12 - 16 BENT STREET LINDFIELD

RESPONSE TO SDRP REVIEW 2 (2 APRIL 25) V2
7.10.2025
STATE SIGNIFICANT DEVELOPMENT APPLICATION

RESPONSE TO
SDRP

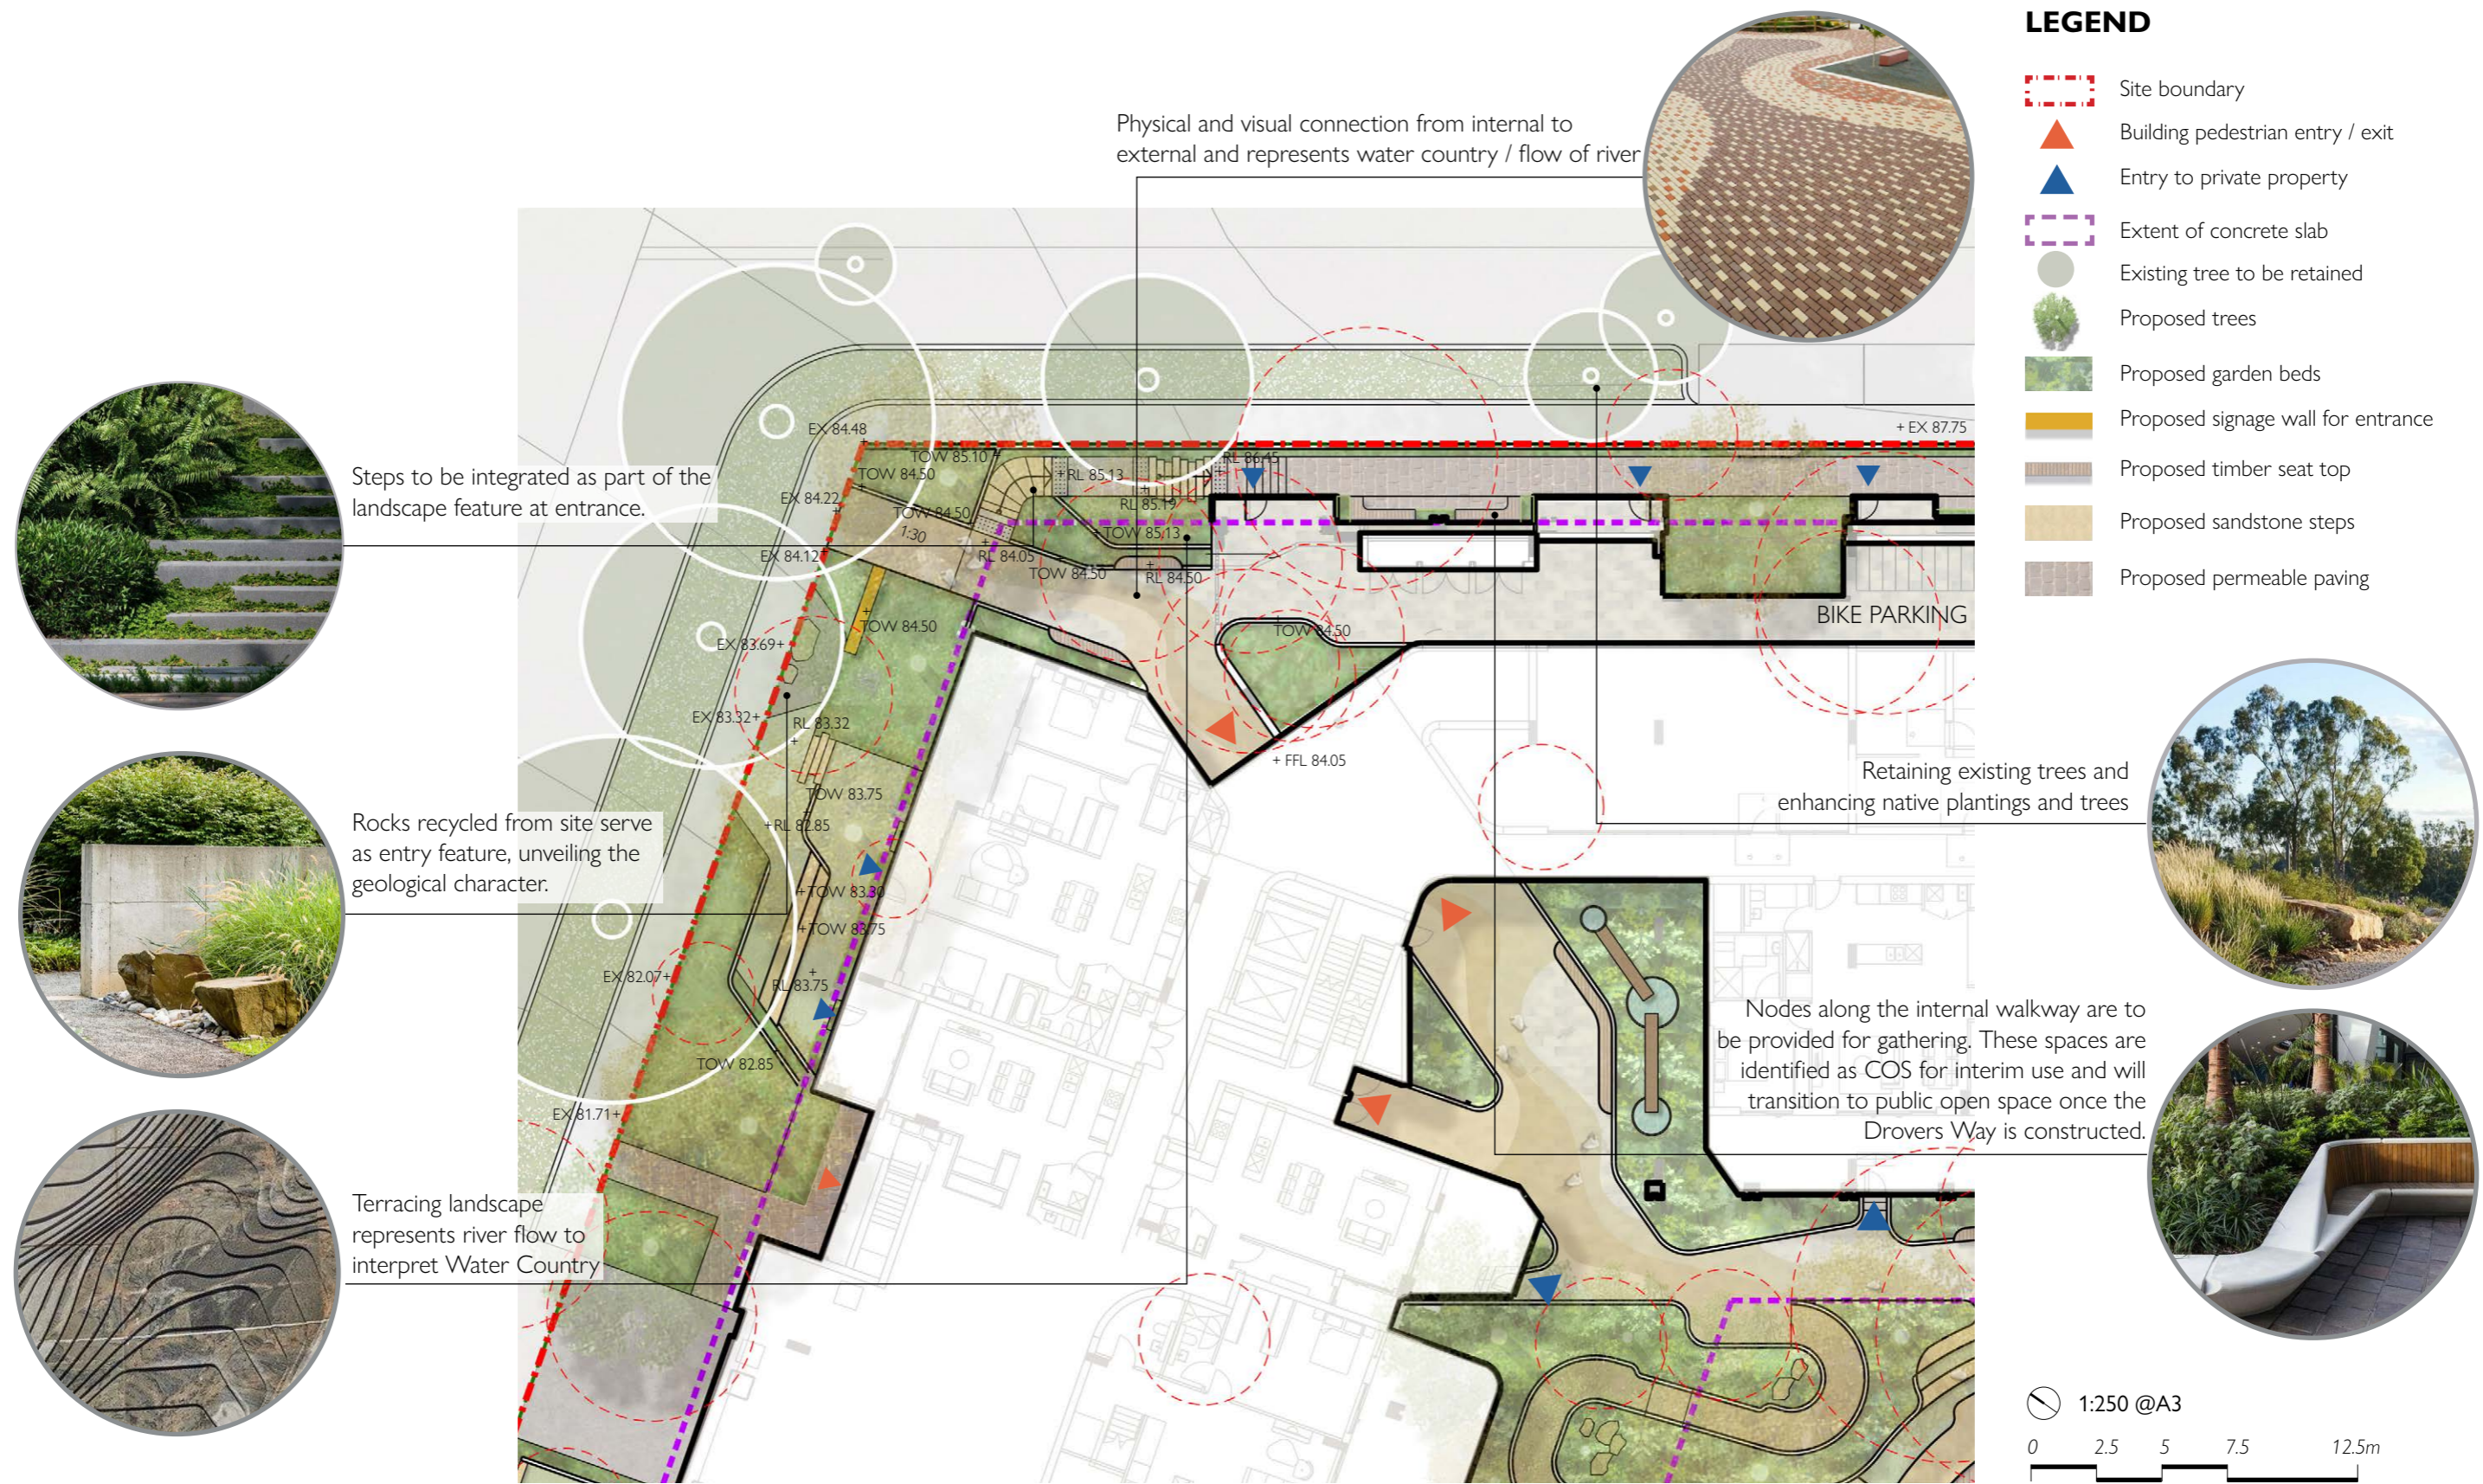
1. Allow the outcomes of the engagement with Aboriginal knowledge holders to guide the design of the areas on the ground plane that still require resolution. Ensure ICIP is observed.

Yerrabingin and the project team will continue to consider Country and outcomes of the engagement in the continued design of the site. Team will continue to observe ICIP in this process.
